**Consultation Response from KC,
Highways Development Management****2026/92204 4, Back Lane, Grange Moor, Huddersfield, WF4 4EJ****Demolition of existing dwelling and garage and erection of 8 dwellings with associated works****Date Responded: 9 September 2026****Responding Officer: Sheila Henley****Responding Ref: 16-6/32****Recommendation: Further information and revisions.**

Plan ref: 2583-D-20-003 Proposed Site Plan Rev A; 2583-D-20-008 Garage Type 01
Reference to planning approval: 2022/92428.

The proposal demolishes an existing 3 bedroomed dwelling and garage and erects eight dwellings of three, four and five bedrooms with access, parking, bin, and cycle storage.

Client	James Walker	Issued From	
Project	2583 - Grange Moor - Housing	Date	March 2026
Title	Garage Type 01	Scale	1:100 @ A1
Drawn	BH	Auth	BH
Drawing Number	Revision		
2583 - D - 20 - 008

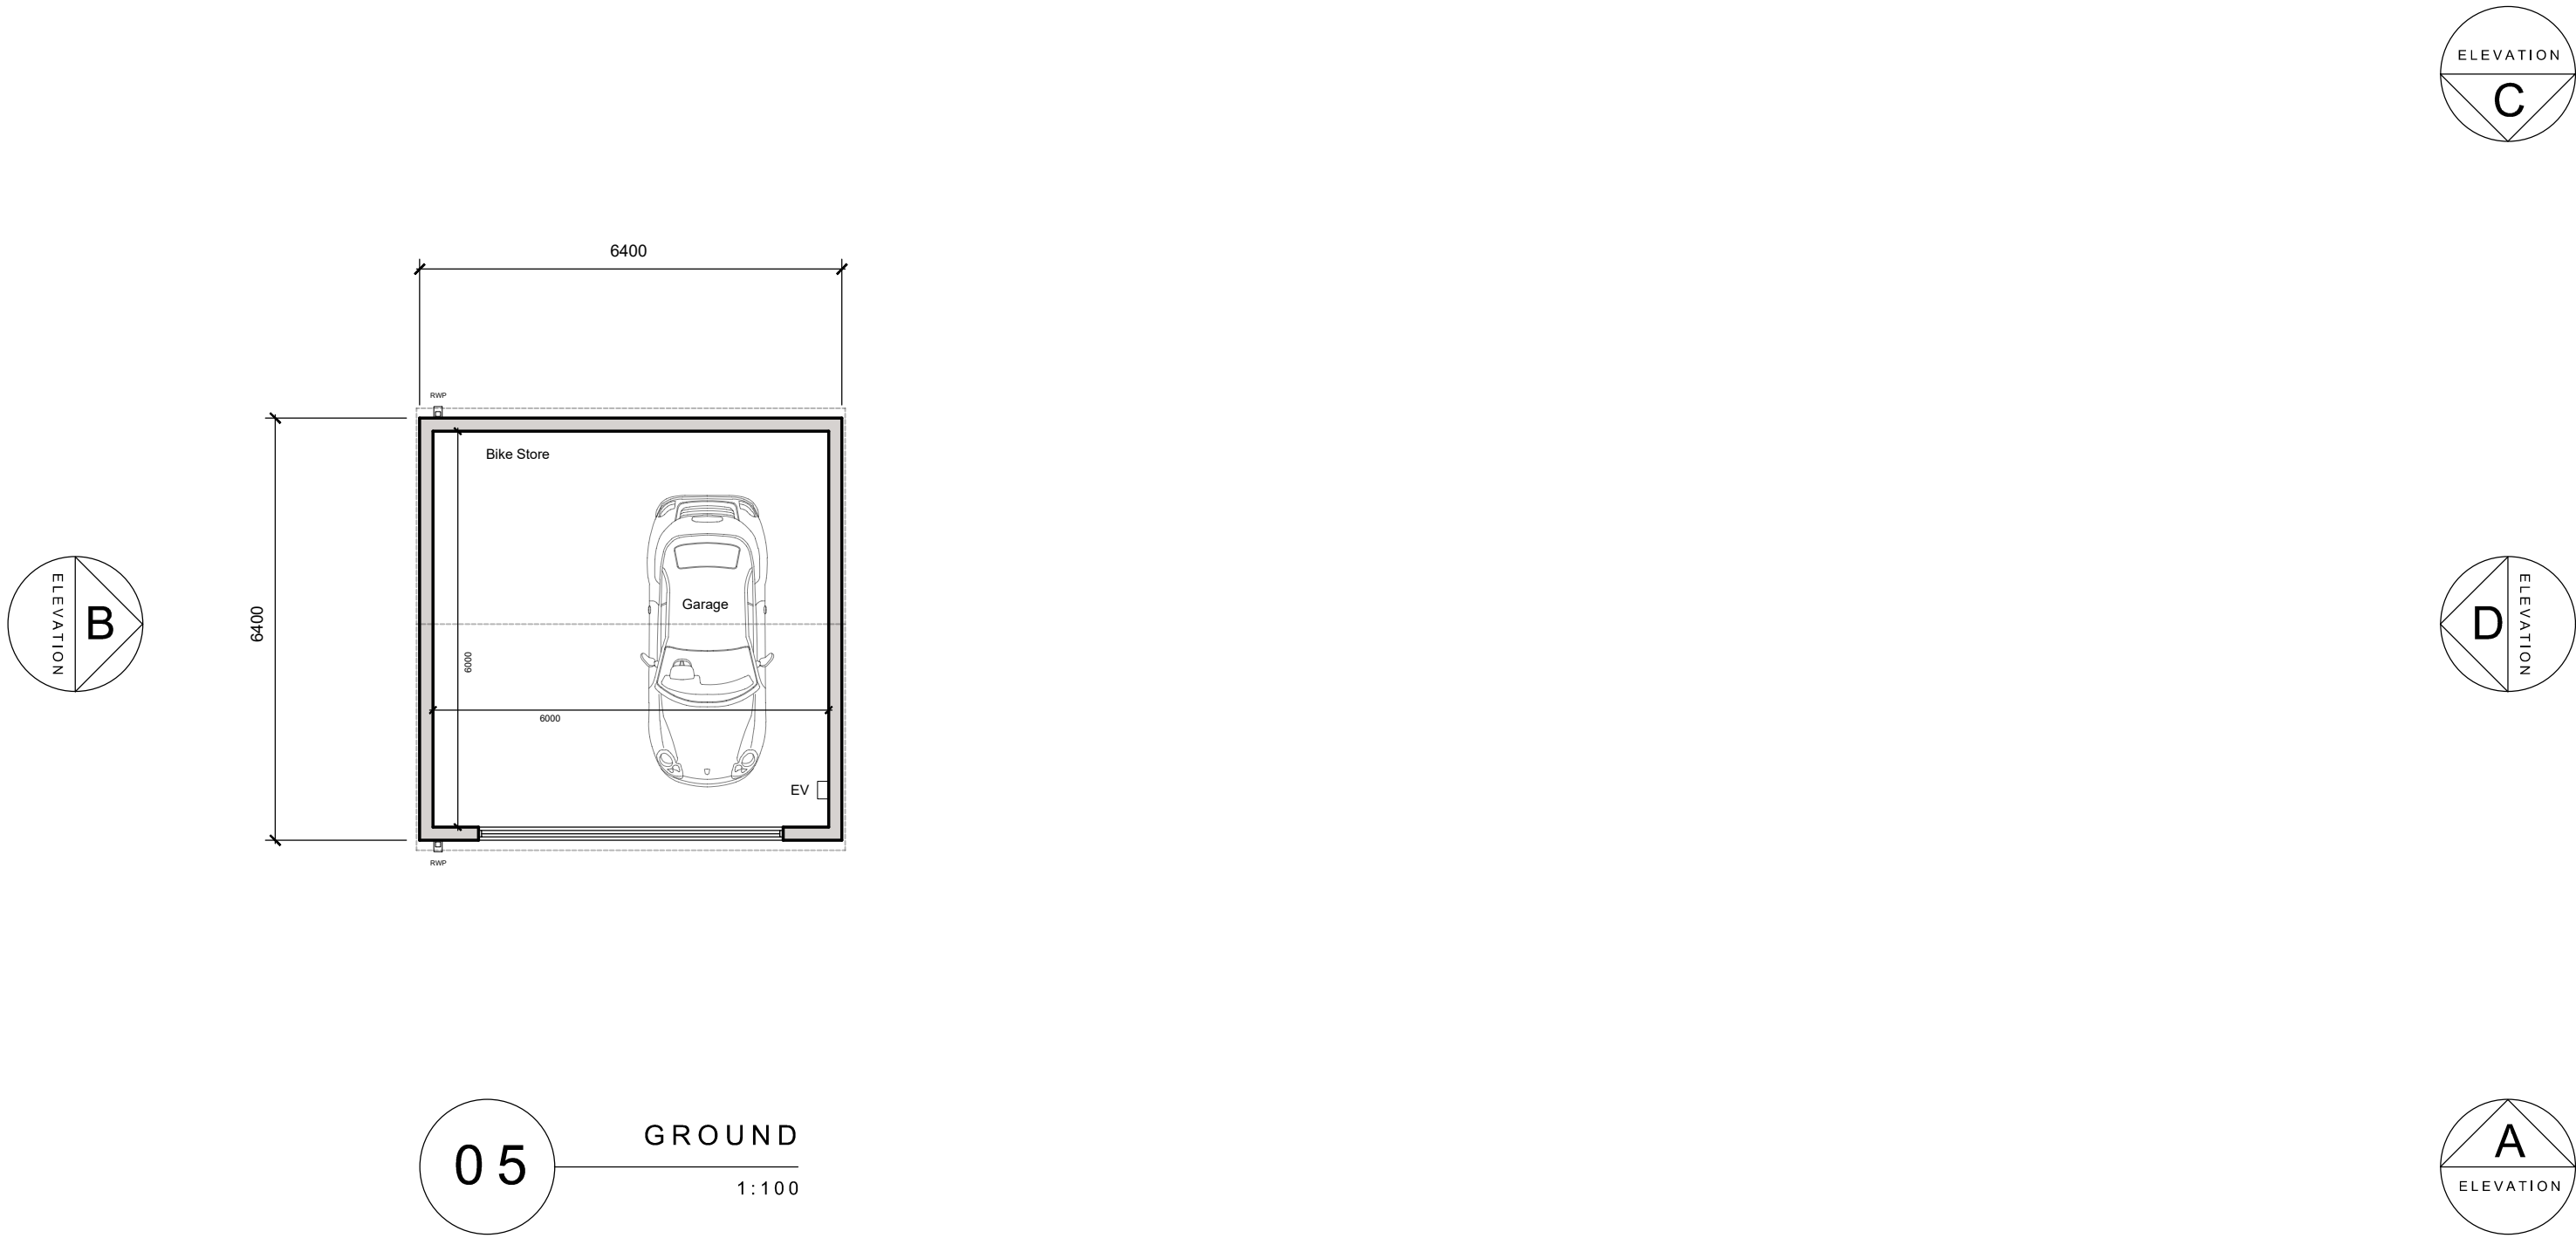
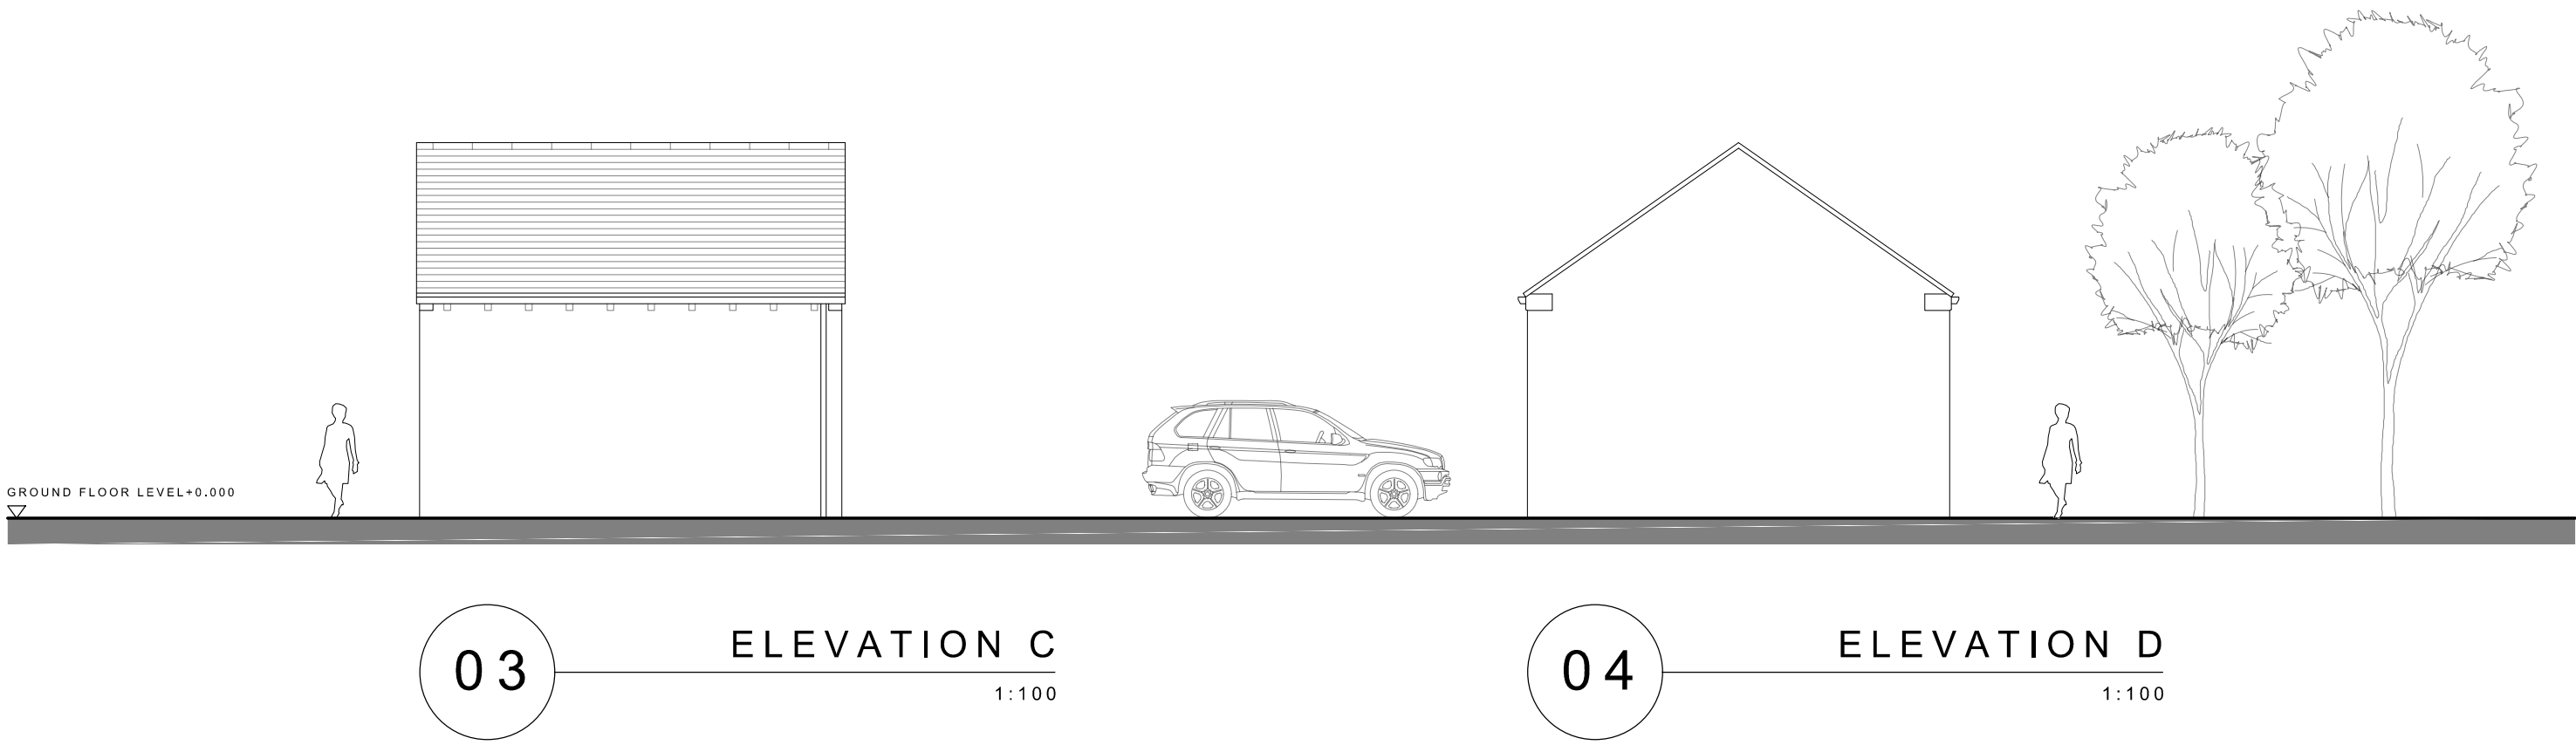
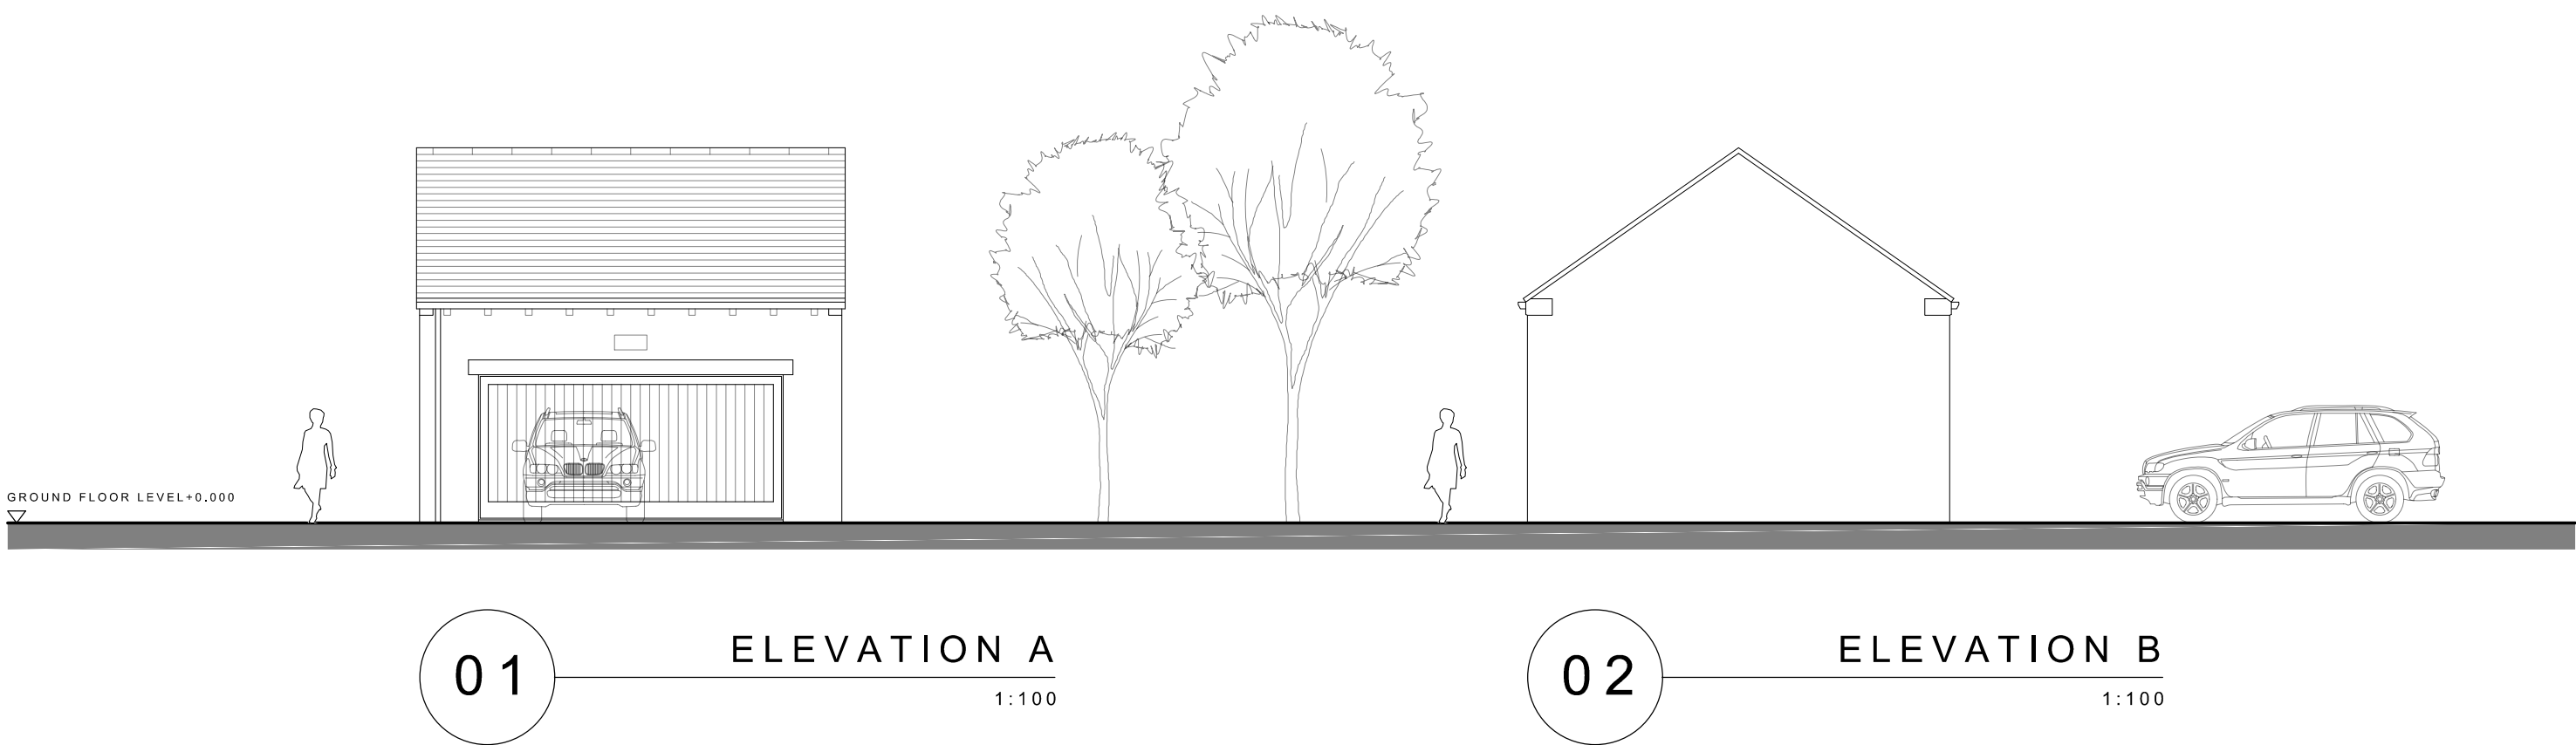
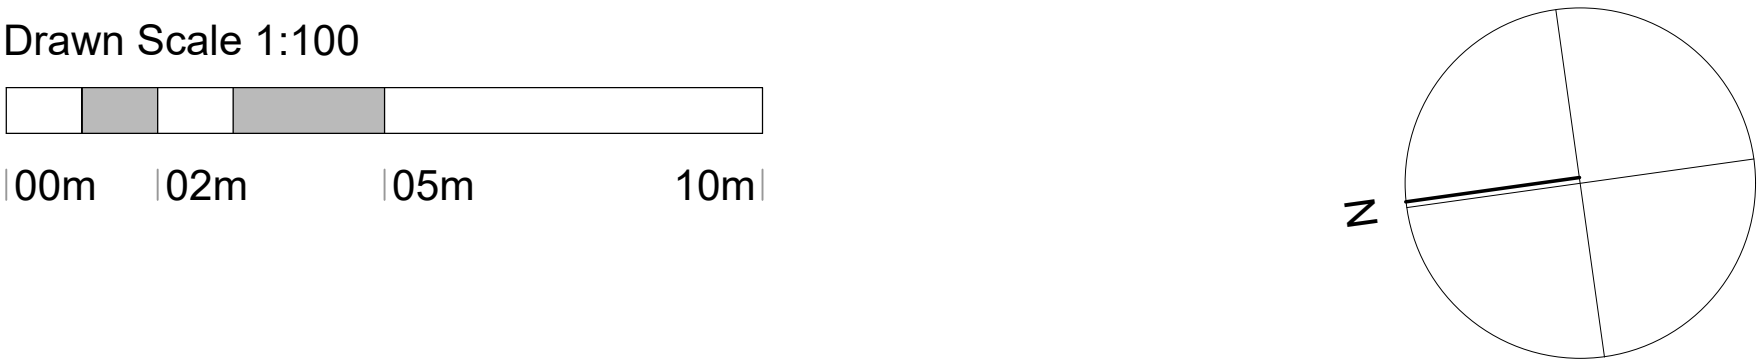
Garages are of sufficient size to count towards car parking and the storage of cycles and other items with doubles at 6.0 x 6.0m and singles at 6 x 3m. That for Plot 1 and its associated exterior parking spaces are divorced from the dwelling and likely to lead to on-street parking in a position that is likely to cause a hazard due to the bend and school entrance. This would require a Traffic Regulation Order restricting on-street parking to overcome, change to the house type or a repositioning within the plot.

The impact on highway safety of the private drive and footway will need to be confirmed through a Stage 1 Road Safety Audit after altering the access to the private drive to the appropriate arrangement. The parking for Plot 1 needs to be reviewed to avoid hazards arising along Liley Lane.

Overall: The site benefits from being accessible with the sustainable travel offer improved by a new footway, cycle parking and evcp's. The existing retaining features relating to the highway are addressed separately. The layout requires adjustment to make it acceptable in highway terms by modifying the access to the private drive to ensure a suitable access for pedestrians. Within the layout, paths to facilitate bin access and movements would be beneficial. The parking and bin arrangements for Plot 1 should be reviewed and the bin storage for Plot 4 clarified.
